Homestead North Phase 1 Updated Traffic Impact Study

SP-20-008
(LSC #204380)
October 19, 2021

LSC Responses to TIS Redline Comments

Figure 1  
**Noise Analysis Data**  
Homestead North Phase 1 Noise Analysis (LSC #204381)

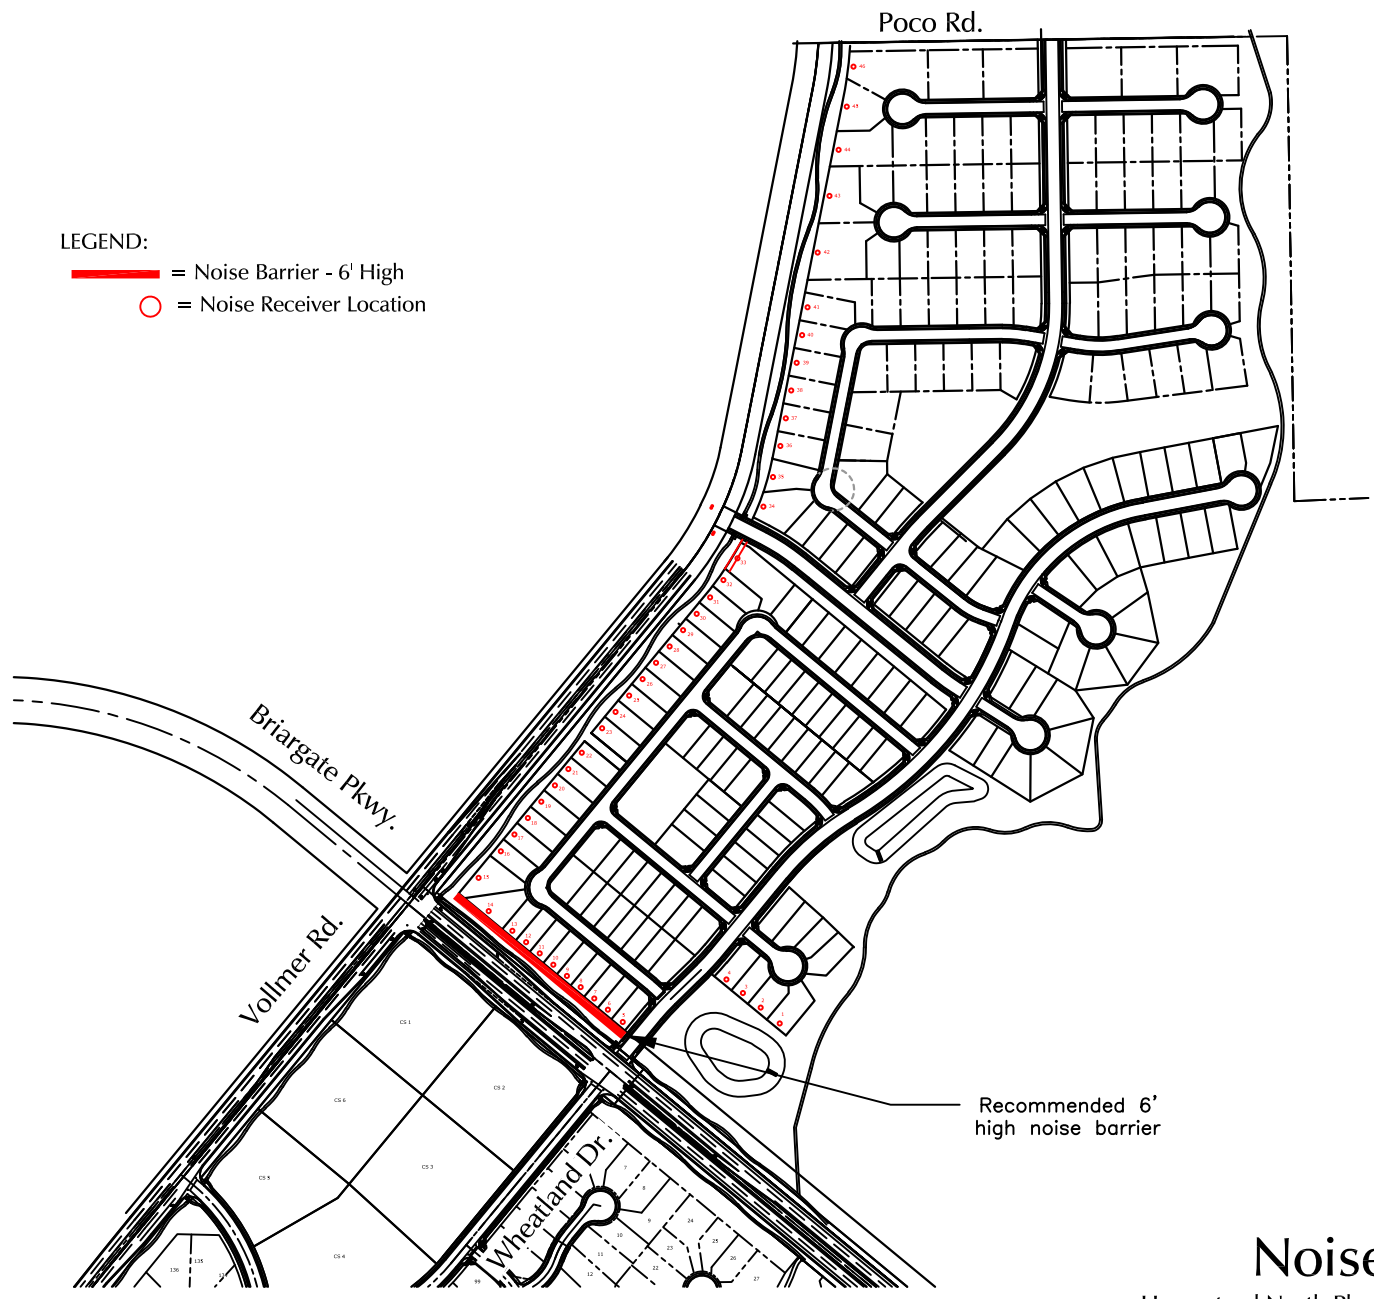
Reference the deviation request in the appendix. Will noise walls be needed for the adjacent lots?

[Reference the deviation request in the appendix. Will noise walls be needed for the adjacent lots?](#)

LSC Response: A copy of the deviation request has been included in the appendix. An updated noise analysis has been submitted that shows noise mitigation will not be needed for lots adjacent to Vollmer Road.
